Arun District Council
Arun Civic Centre
Maltravers Road
Littlehampton
West Sussex BN17 5LF
Planning & Building Control General Enquiries
Tel: (01903) 737756 Fax: (01903) 730442
Dx: 57406 Littlehampton
Minicom: 01903 732765
e-mail: planning@arun.gov.uk
website: www.arun.gov.uk/planning

Application No: AW/81/21/HH
Site Address: 2 Old Farm Close Aldwick PO21 4AX
Description of works: Two storey extension.

Thank you for your internet representation made on 9th April 2021 which has been recorded as an objection with the comments as follows:

Proposed second floor plan 1:100

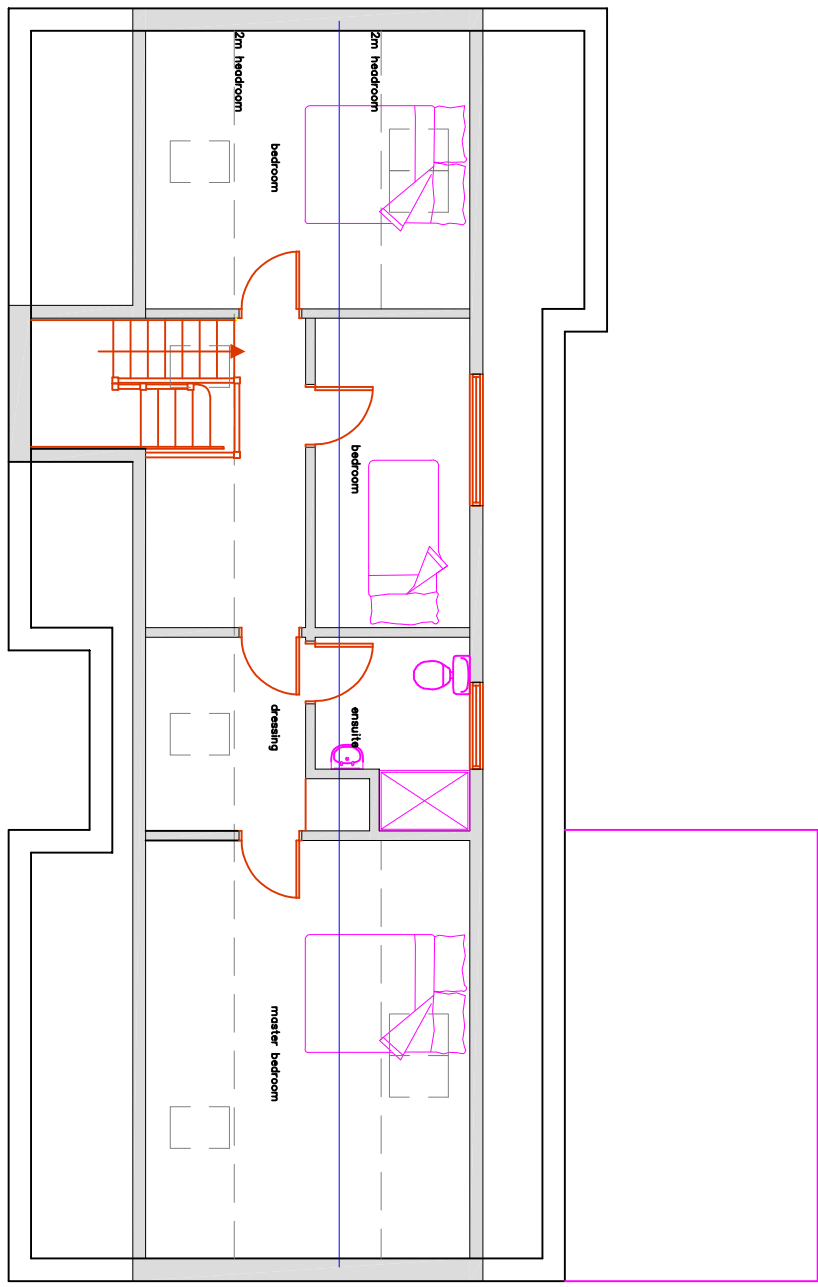
The description of the application as a "two storey side extension" is inaccurate. It is a three-story side extension (including loft room) plus loft conversion of the existing house. The size of the extension and alterations to the existing house (resulting in a seven-bedroom house with a two-bedroom annex or nine-bedroom single dwelling) are disproportionate to achieve the aim of creating "accommodation for increasingly dependent relative". It will compromise the established spatial character and pattern of Old Farm Close causing demonstrable harm to the visual appearance and Georgian style design which is a key feature of the Grangefield and Alborough Way estate of which it is a part.

Extensions and alterations are required to "not have an adverse overshadowing, overlooking or overbearing effect on neighbouring properties" (DDM4). The conversion of the existing loft into living accommodation with new windows in the roof front and back, plus the windows and balcony in the extension and its loft will have an adversely overlooking effect on all neighbouring properties including those in Old Barrack Lane at the rear of the property. In particular it will have a detrimental adverse effect on us as the immediate neighbour nearest the extension because the balcony on the rear of the extension will directly overlook our garden and into our conservatory.
